TO: New Home
ATTN: Steven Kirby
PROJECT #: 21-2780-B (11-WB)
PAGE: 1 of 1
DATE: October 4, 2023
LOCATION: 359 Yates Mill Drive, Fuquay Varina NC
PLAN REF: Lot 11 Woodbridge South by New Home
 Project# 21-2780

THE FOLLOWING CHANGE(S) OR PROPOSED CHANGE(S) LISTED BELOW ARE DEVIATIONS OR CLARIFICATIONS FOR THE ABOVE REFERENCED PLANS:

**CRAWL FND. W/ ~~OPT. FIREPLACE~~
@ EXT. COVERED PATIO/PORCH**
SCALE: 1/8"=1'-0" ON 11x17, 1/4"=1'-0" ON 22x34

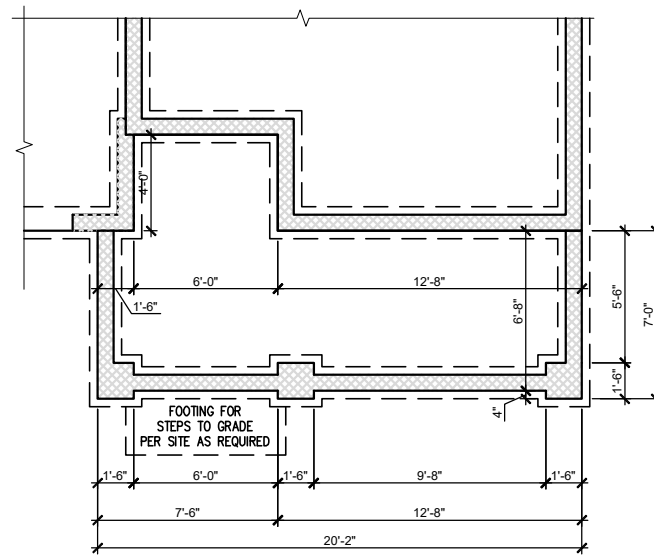
(3) 2X6 JACK STUDS AND
 SINGLE 2X6 KING STUD.
 ADDITIONAL 4 STUDS ADDED
 AT THE CORNER.

OPT. FIREPLACE AT PATIO
 SCALE: 1/8"=1'-0" ON 11x17, 1/4"=1'-0" ON 22x34
